Application No: 19/00213/DISC

Proposal: Discharge of conditions 6 (new link road), 8 (surface water drainage), 9 (floor levels), 10 (play areas), 11 (arboricultural survey), 12 (ecology), 13 (secured by design), 14 (contamination), 18 (mitigation for badgers) and 35 (cycle lanes) of 15/01326/OUT

Location: OS Parcels 6741 And 5426 West Of Cricket Field Nor Wykham Lane Bodicote

Lead Local Flood Authority

TITLE: **Adoptable Drainage**

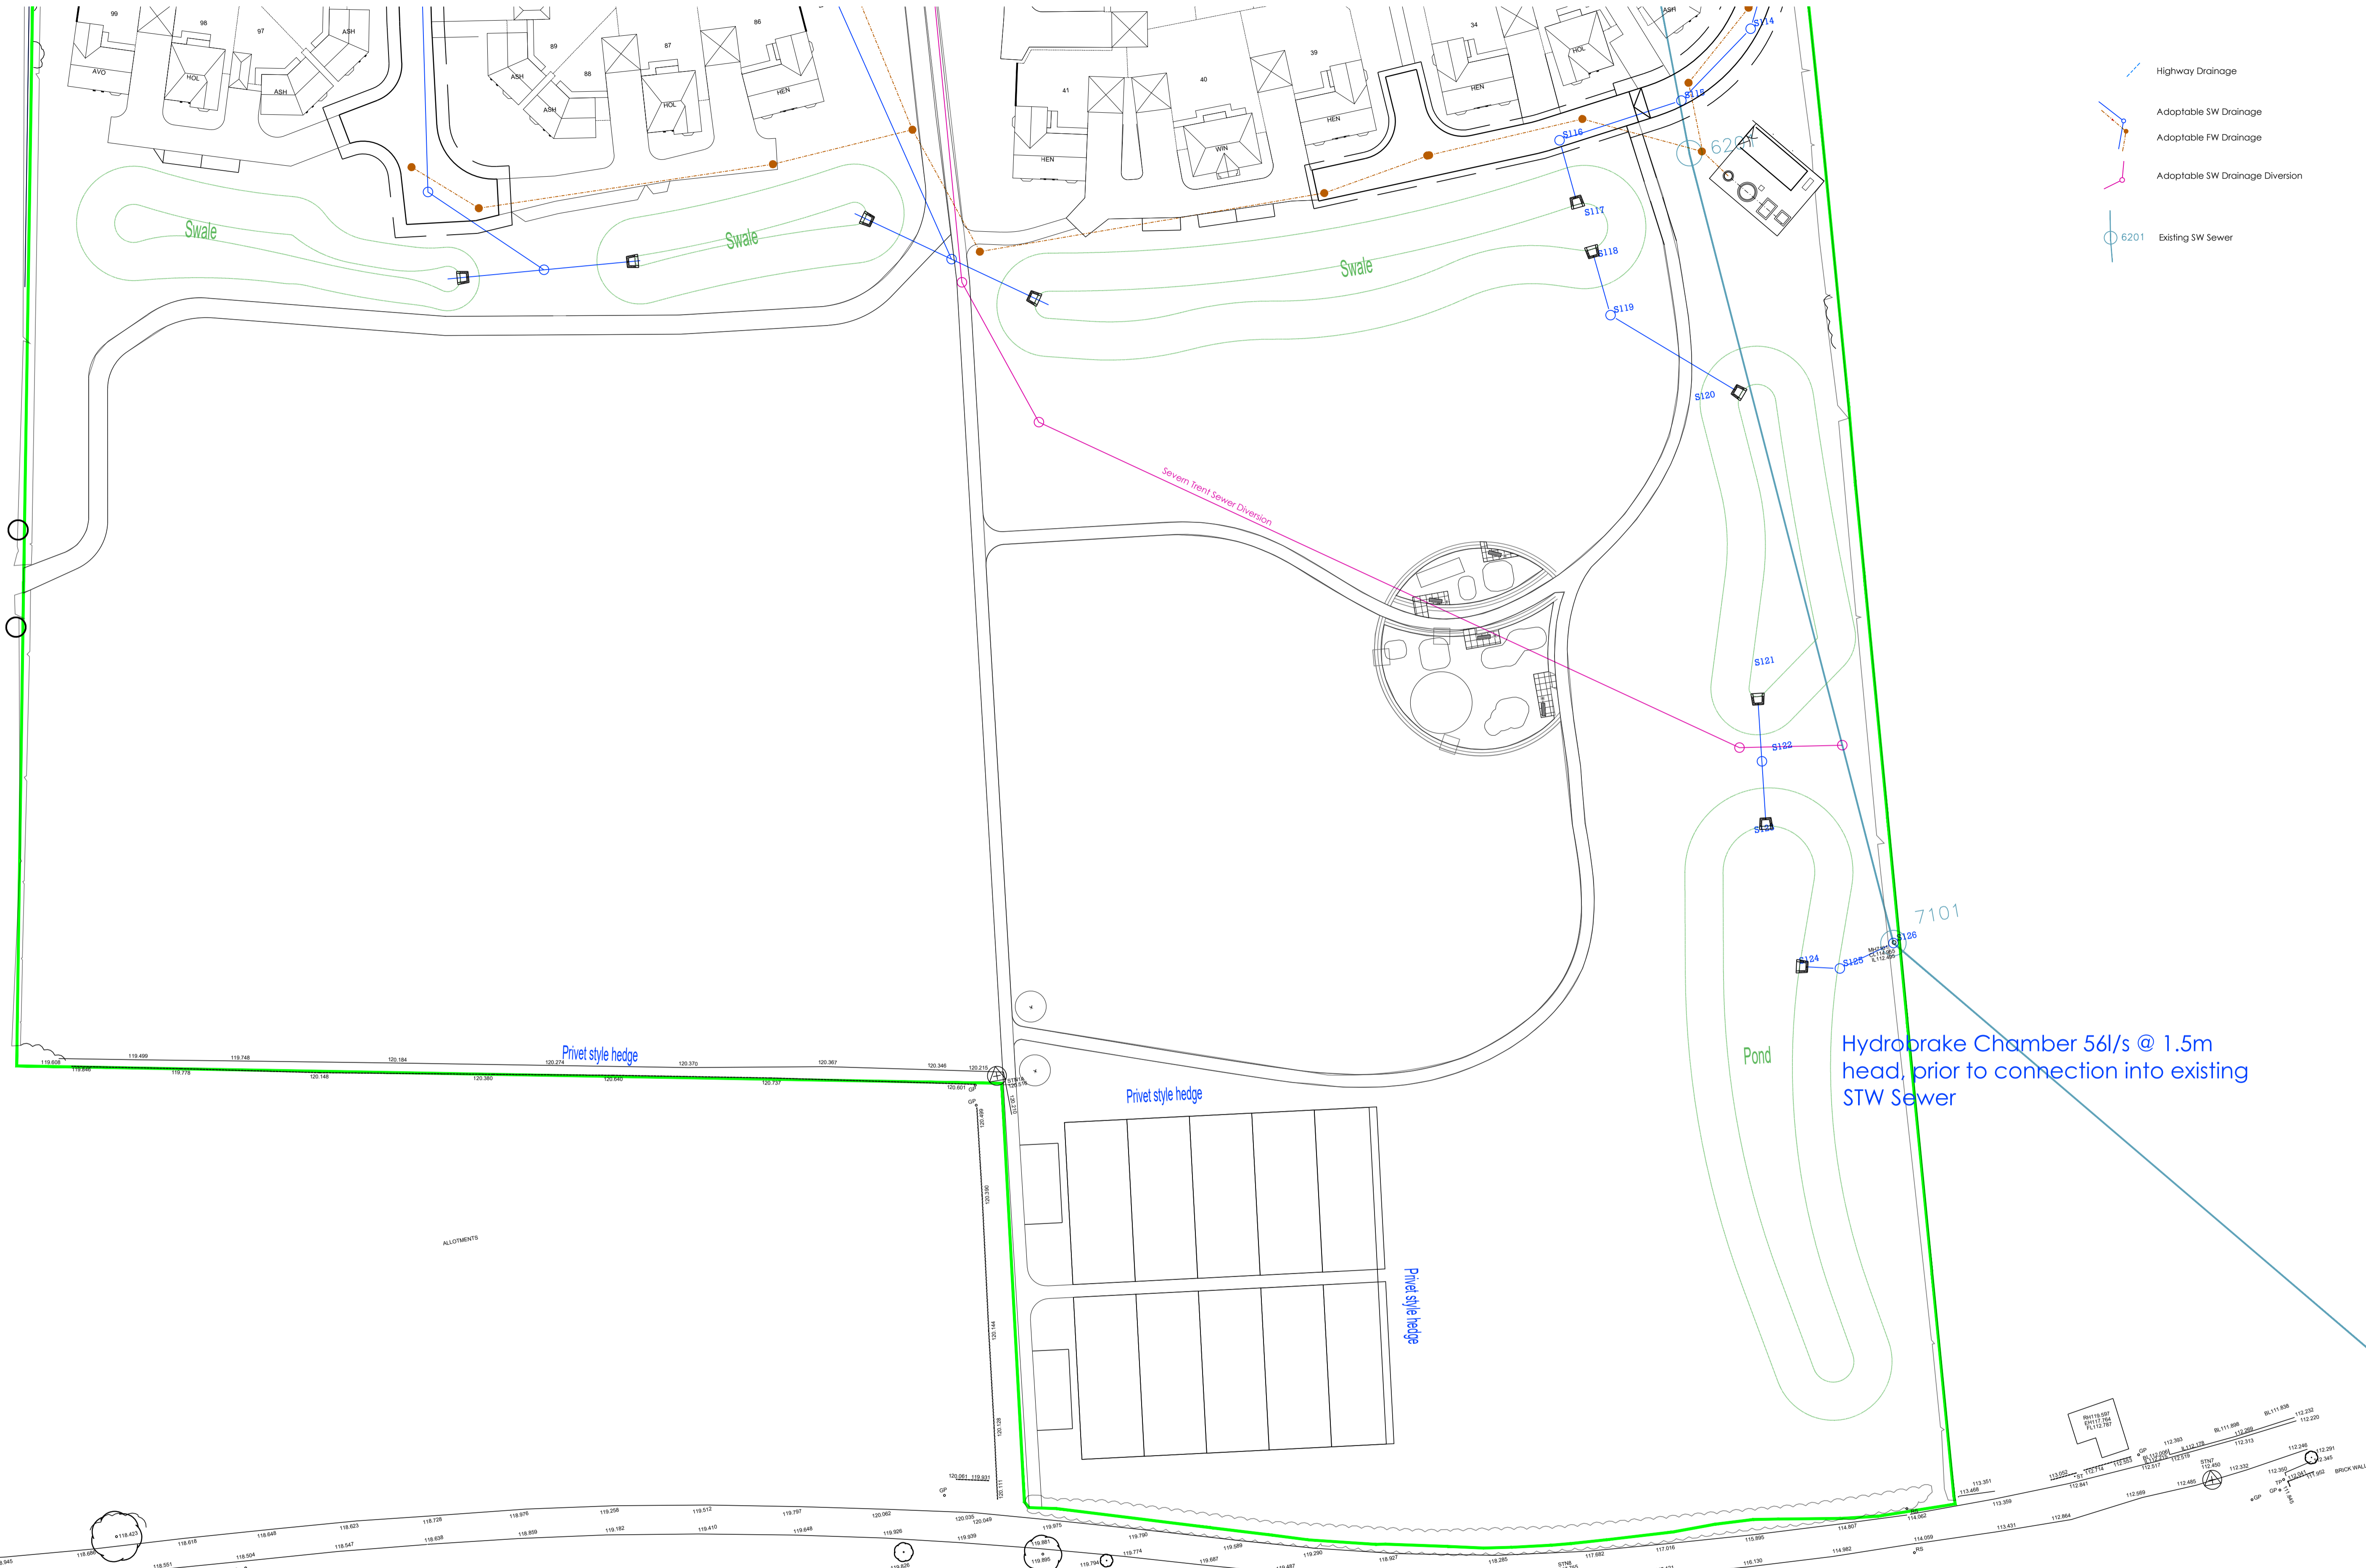
- Ø Level of detail insufficient to discharge condition
- Ø Layout insufficient to manage surface water flow routes crossing the site.

Only drawings have been submitted. We require further details including the following;

- A compliance report to demonstrate how the scheme complies with the overall drainage strategy for the site and current local and national surface water drainage standards;
- Full microdrainage calculations for all events up to and including the 1 in 100 year plus climate change;
- Full infiltration tests to BRE 365 at the location of each infiltration feature;
- Details of how existing surface water flow routes will be maintained and managed post development;
- A Flood Exceedance Conveyance Plan;
- Detailed design drainage layout drawings of the SuDS proposals including cross section details;

We have objected to the reserved matters application related to this site 19/01037/REM as existing flow routes through the site are not being respected and maintained. These were highlighted in the initial flood risk assessment and there was scope in the original masterplan for these to be maintained through green space that was being retained. These have now been removed in the latest plans.
